WEST SUSSEX COUNTY COUNCIL CONSULTATION

TO:	Arun District Council FAO: Michael Eastham
FROM:	WSCC - Highway Authority: Tim Townsend
DATE:	8th December 2020
LOCATION:	Land south of Ford Lane and East of North End Road Ford BN18 0DS
SUBJECT:	Y/139/20/DOC Approval of details reserved by condition imposed under ref APP/C3810/W/17/3170059 (Y/80/16/OUT) relating to Condition No 10 - Construction Method Statement
DATE OF SITE VISIT:	19th October 2020
RECOMMENDATION:	More Information Required
S106 CONTRIBUTION TOTAL:	N/A for this application

This is the WSCC County Highway Authority (CHA) response to the above planning application for approval of details reserved by condition imposed under ref: APP/C3810/W/17/3170059 (Y/80/16/OUT) relating to Condition No 10 - Construction Method Statement.

Drawing Title
LEVELS AND DRAINAGE

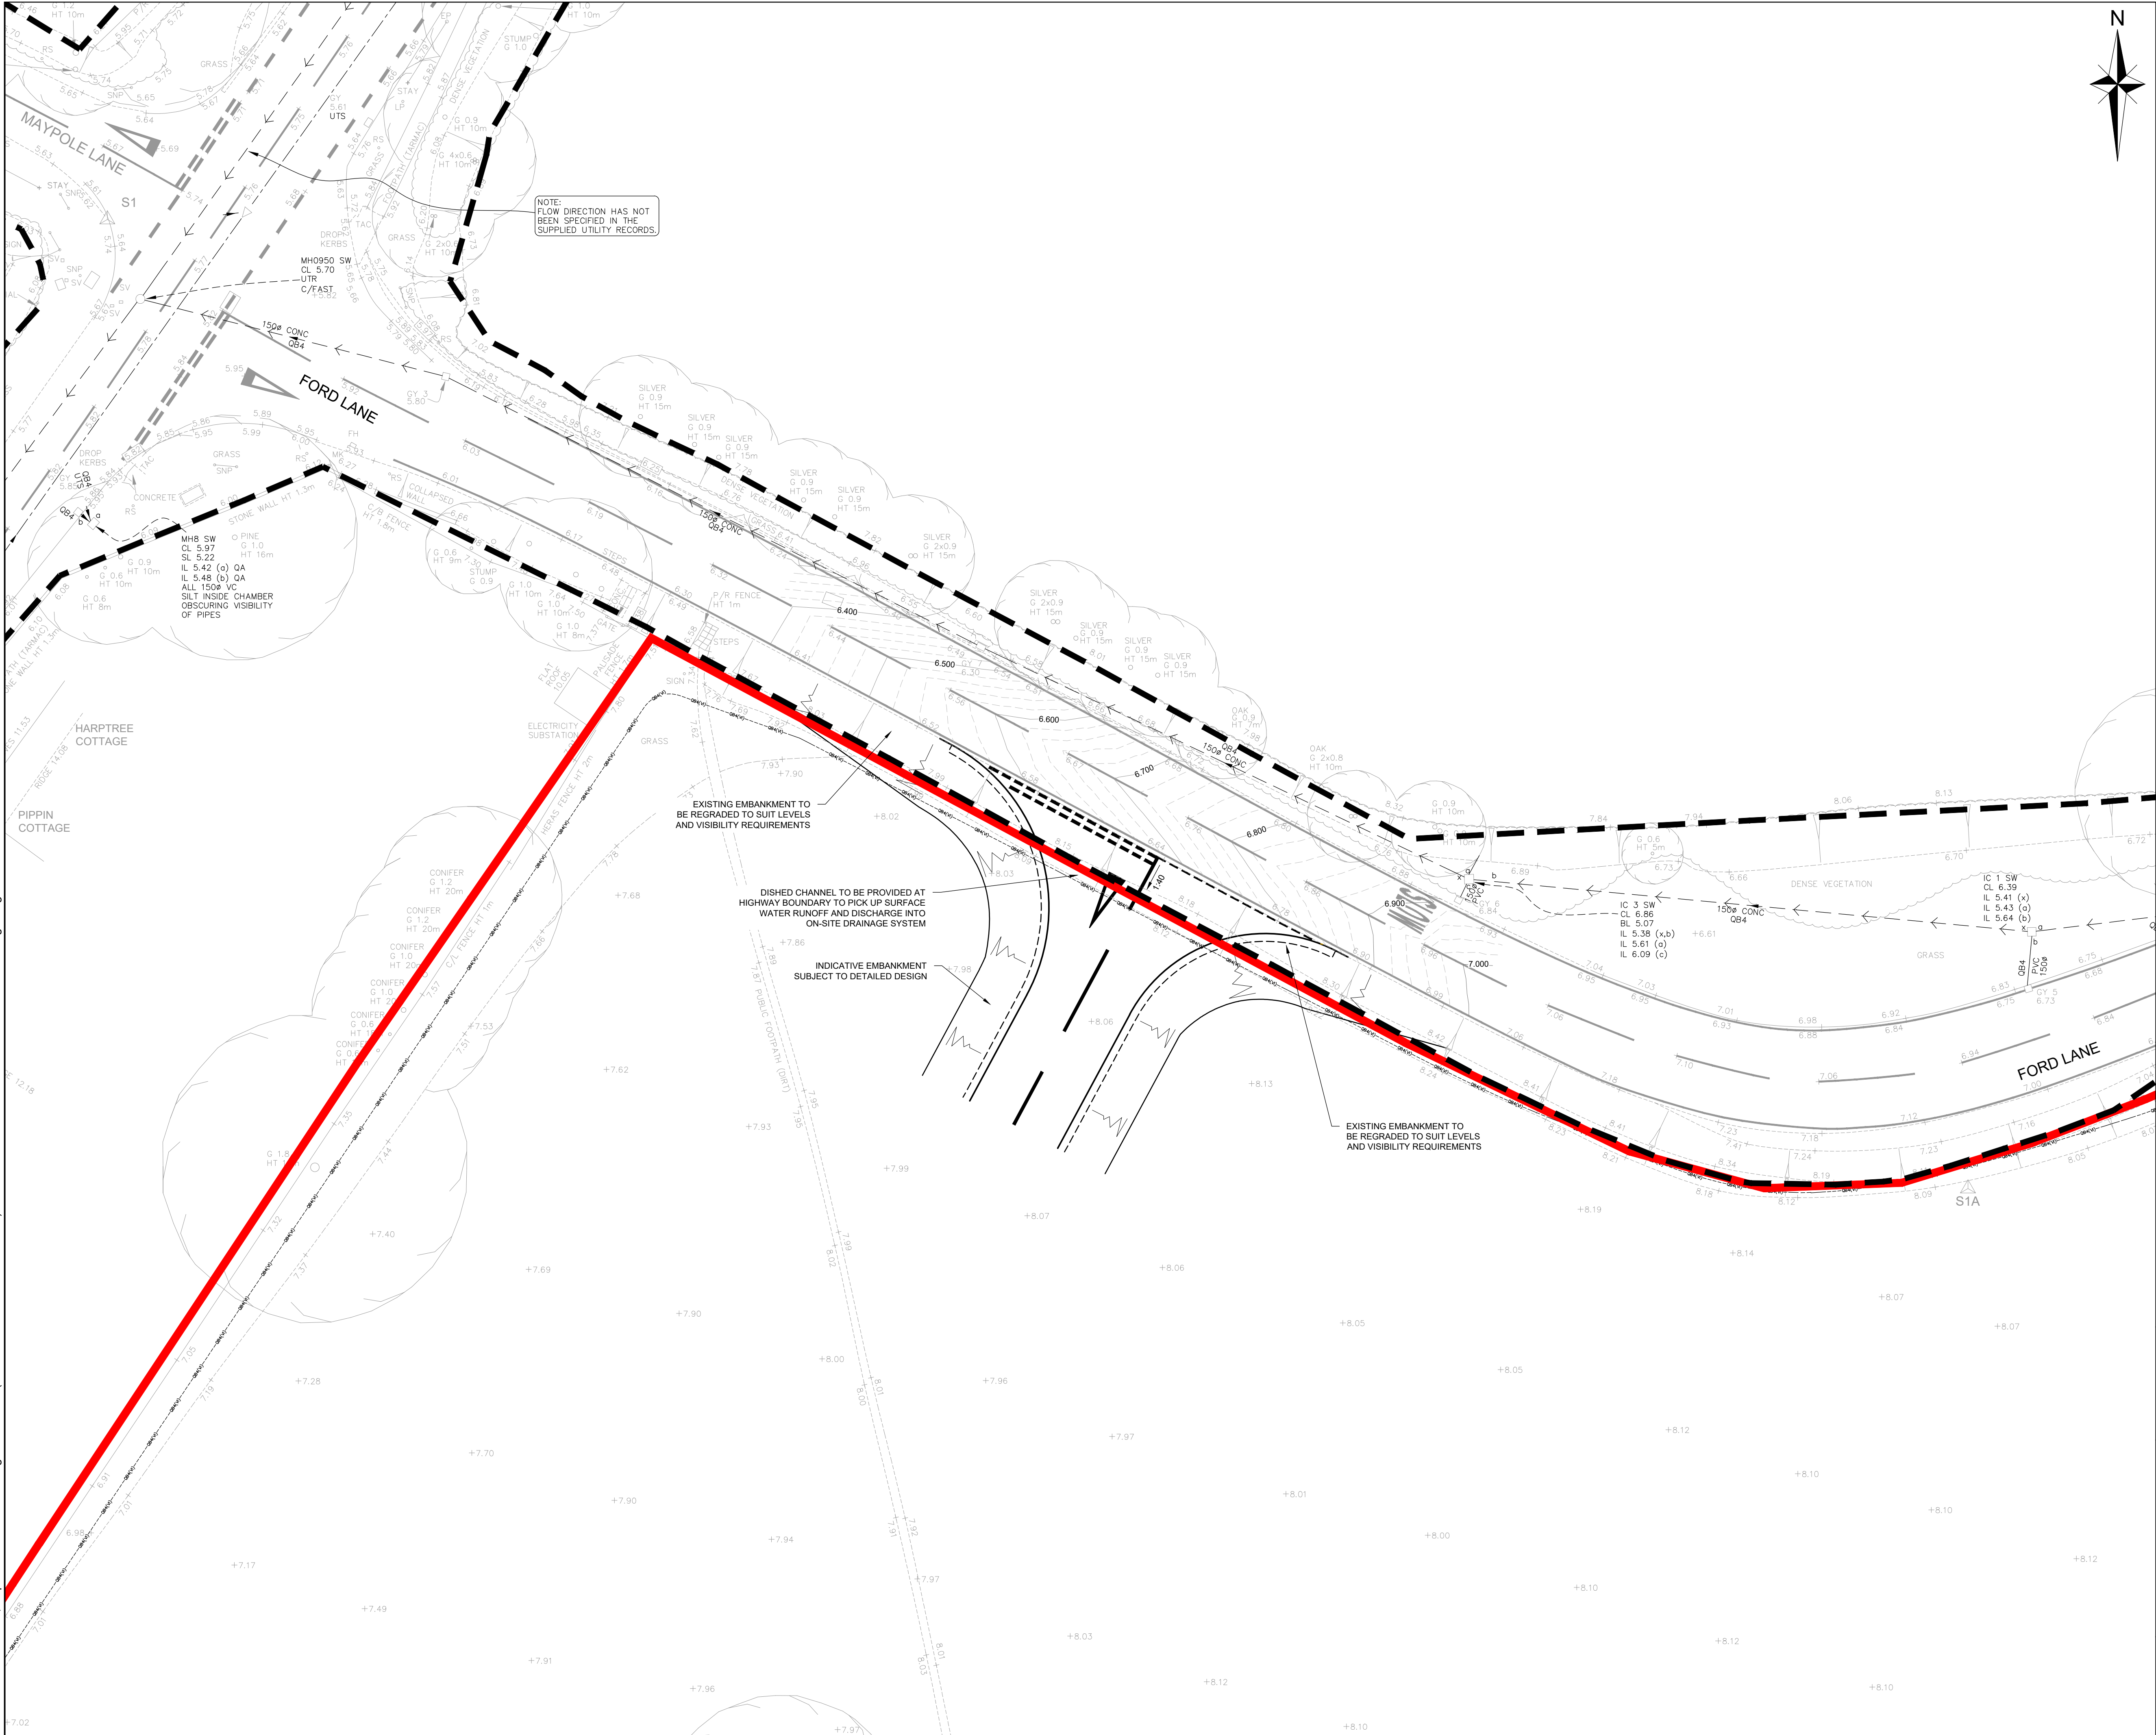
Point 1 was replied to satisfactorily (although for purposes of completeness it should be made available again in response to this current application). However, while a Stage 1 Road Safety Audit was provided, it was not concluded to the satisfaction of the CHA (namely to do with surface water drainage and site access visibility splays and forward visibility for oncoming traffic). For point 3, the additional information requested was not supplied.

GENERAL ARRANGEMENT

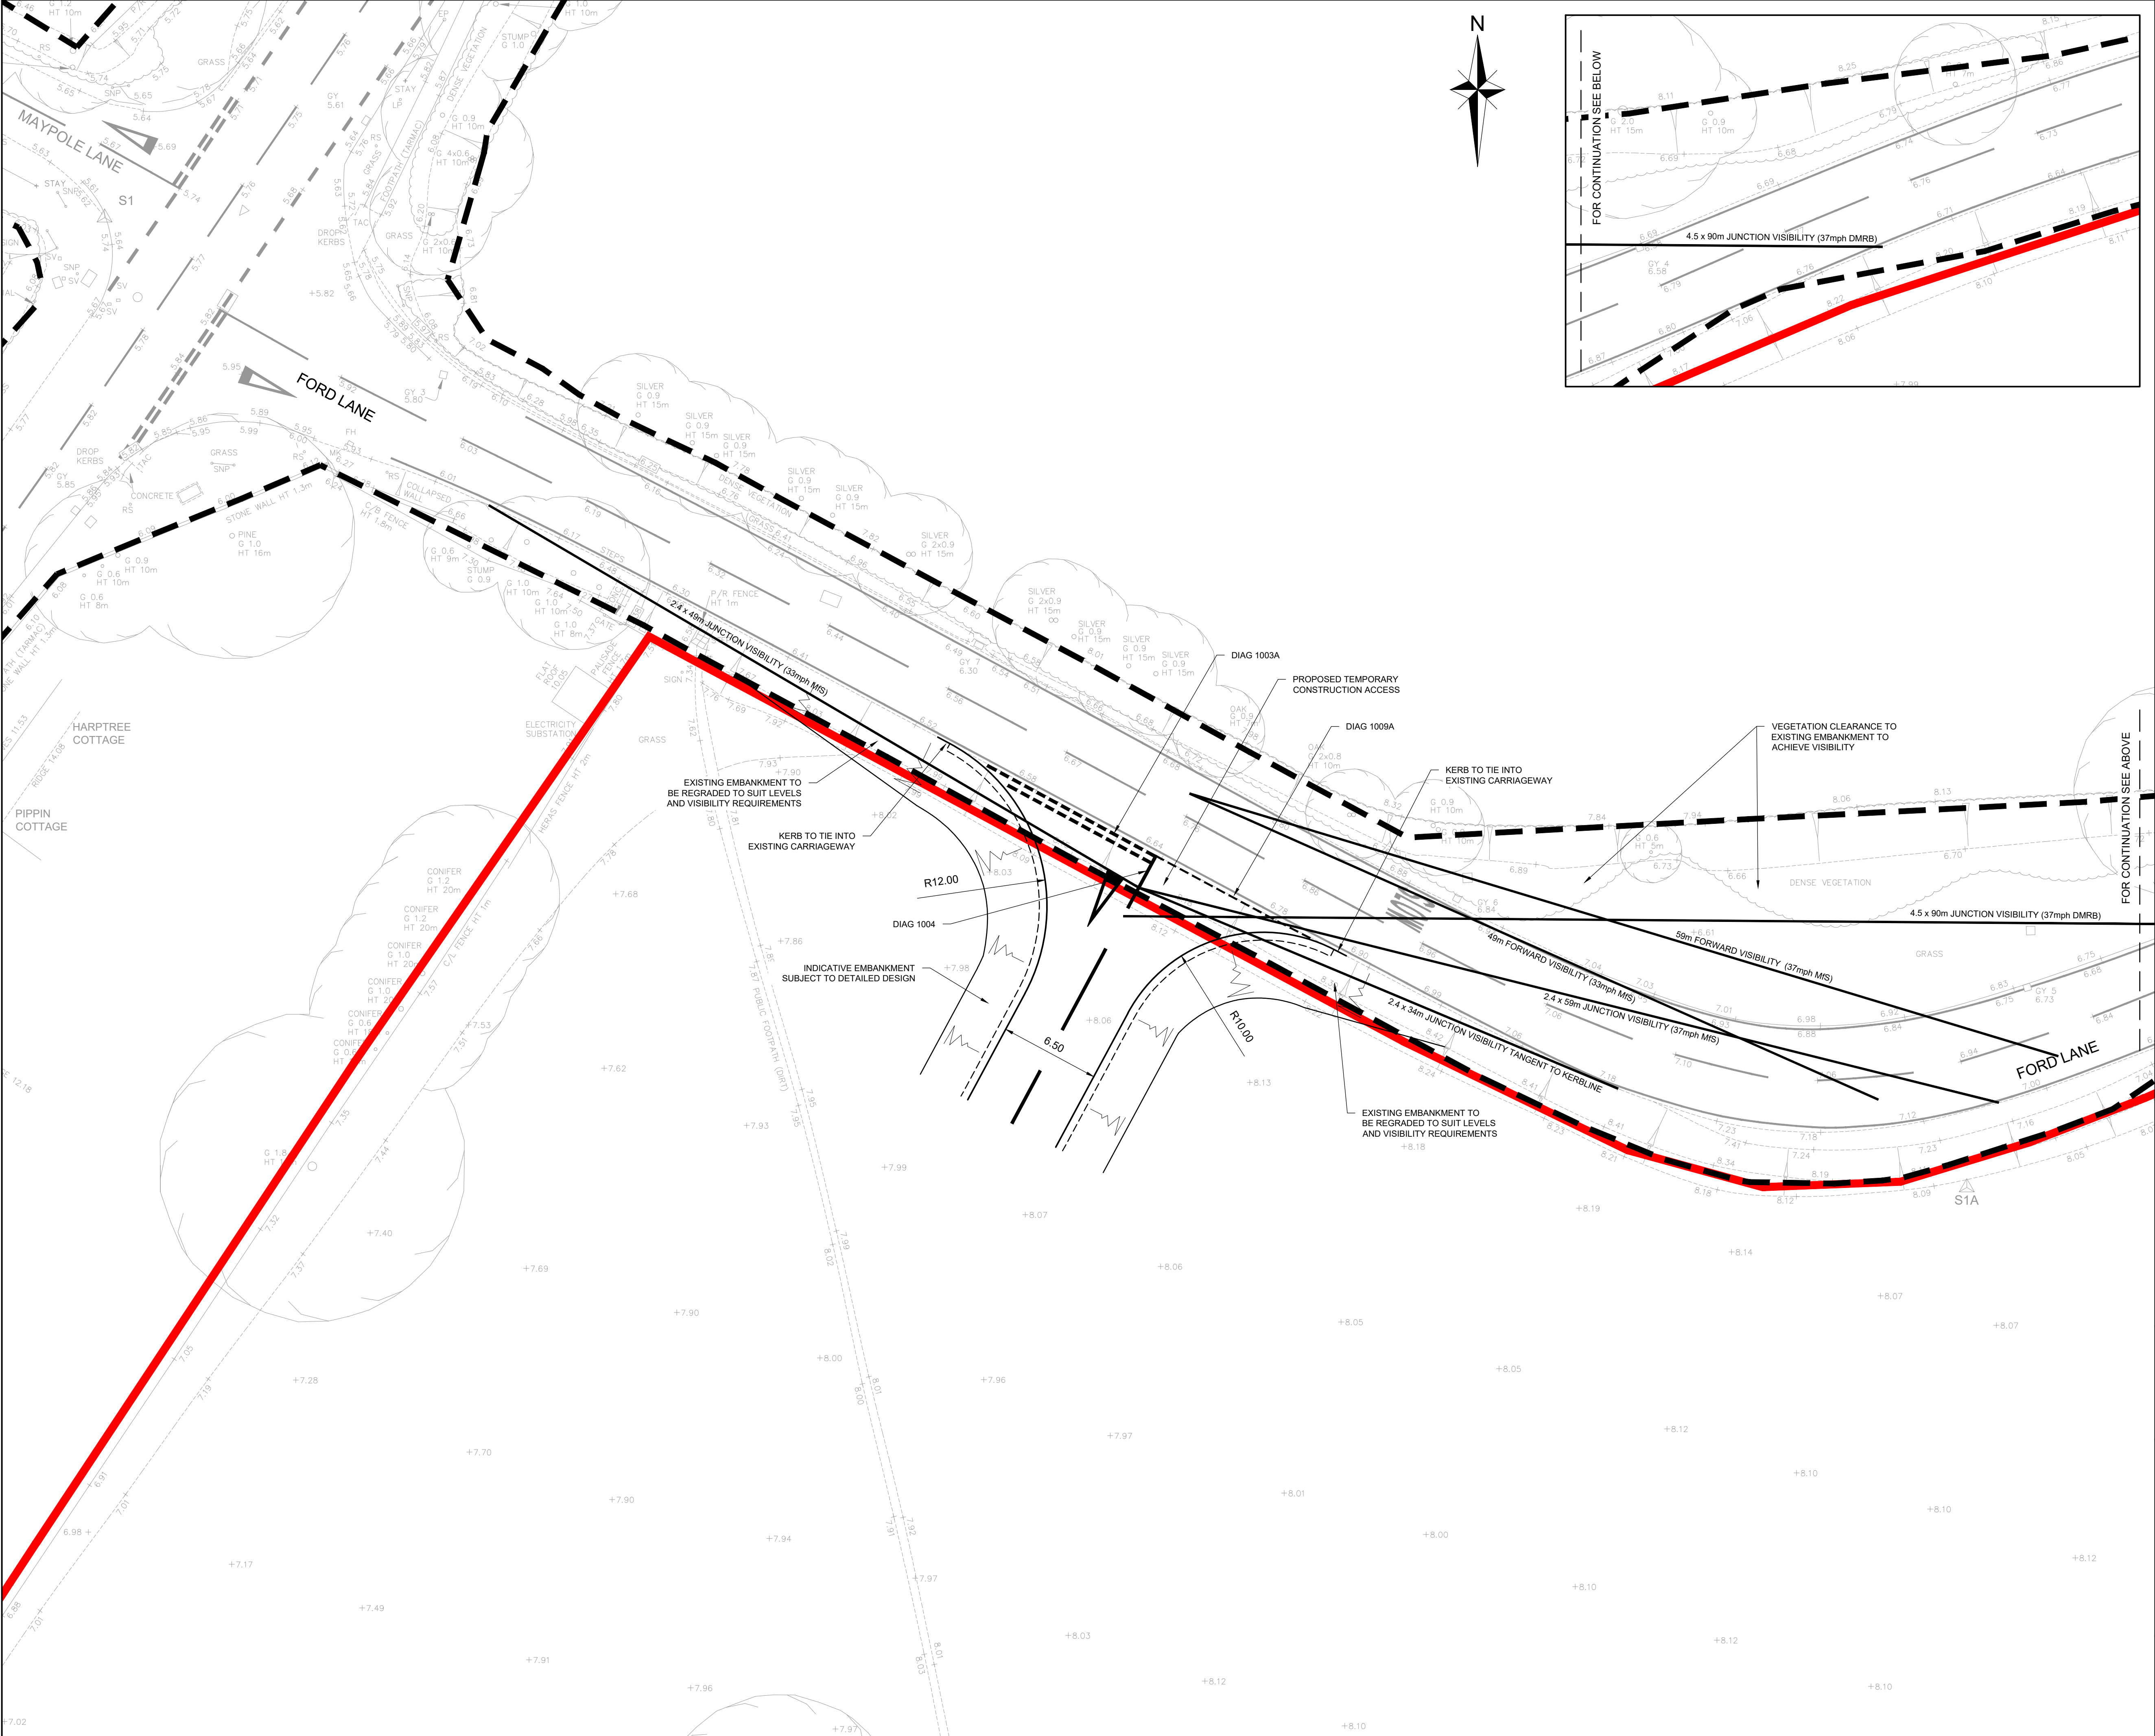
1. Reference to street sweeping for Ford Lane as well.
2. Further detail of routing arrangements for all construction vehicles. The CMP should also state that use of North End Road south of the junction with Ford Lane will not be used for construction traffic routing to and from the site.
